Planning & Urban Development Department

February 22, 2016

Re: 31 & 35 Rear Brookside Road – 158-A-006, 010 & 026 (the "Property") – R-2 Residential Zone and Shoreland Overlay Zone – illegal stairs and deck

EXISTING CONDITIONS PLAN OF 31 BROOKSIDE ROAD PORTLAND MAINE

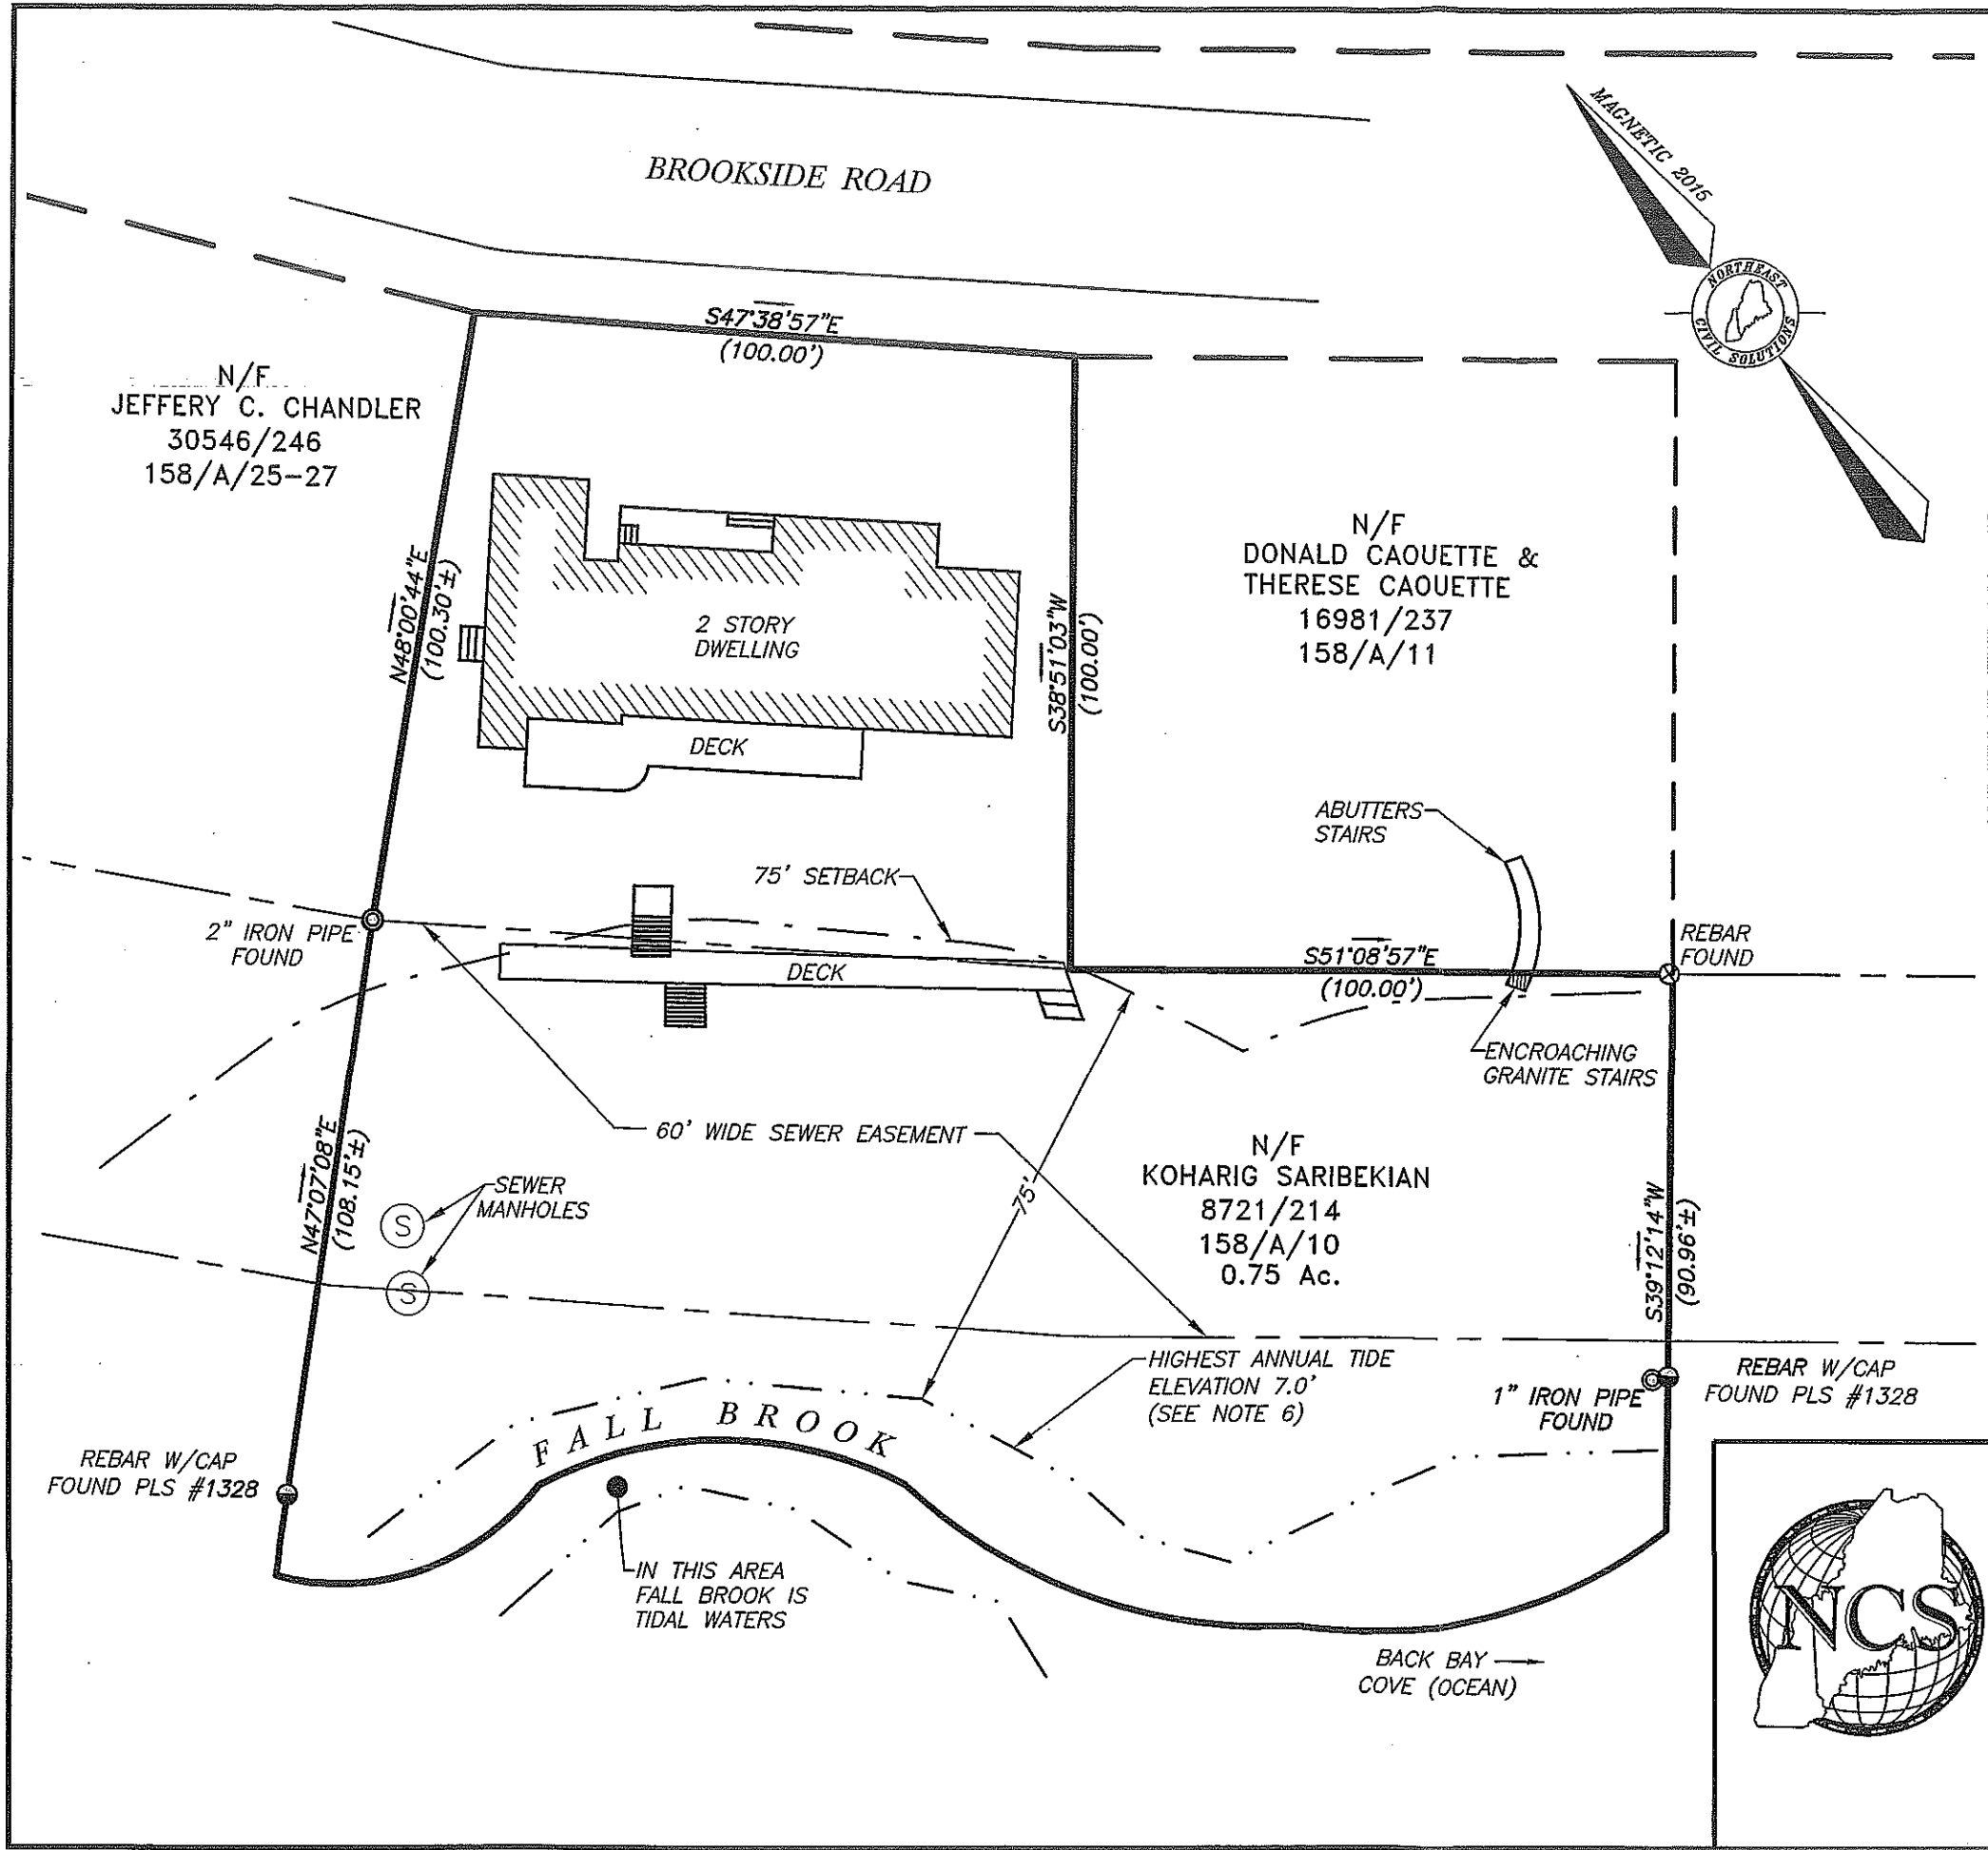
As I stated in my letter dated July 17, 2015 (attached), you erected the stairs and deck behind your house without a permit. In this letter, you were asked to submit an after the fact building permit or remove the structure within thirty days. I received the after the fact building permit application from Jim Fisher on December 8, 2015. The Property is located in the Shoreland Zone. The Existing Conditions Plan of 31 Brookside Road Portland Maine Prepared for Koharig Saribekian by Northeast Civil Solutions dated November 5, 2015 shows the seventy-five foot Shoreland setback from the highest annual tide. This plan shows that all but the top landing of the stairs is located within the seventy-five foot setback. § 14-449(a)(1) of the ordinance states:

- (a) *Principal and accessory structures:*
1. All principal and accessory structures shall be set back at least seventy-five (75) feet horizontal distance, from the normal high water line of water bodies, the upland edge of a wetland or associated tributary streams within a shoreland zone...

Since the two sets of stairs and the deck are located within seventy-five of the highest annual tide, they cannot be permitted and must be removed. I understand that you received a Permit By Rule from the Department of Environmental Protection, but this permit is issued under the National Resources Protection Act Permit By Rules Standards, Chapter 305. This is separate from the Shoreland Zone regulations which also have to be met.

You need to bring your property into compliance. Normally, you would have thirty days to bring your property into compliance, but since it is still winter, the deck and stairs need to be removed by May 1, 2016. An inspection will be scheduled at this time to confirm that the deck and stairs has been removed.
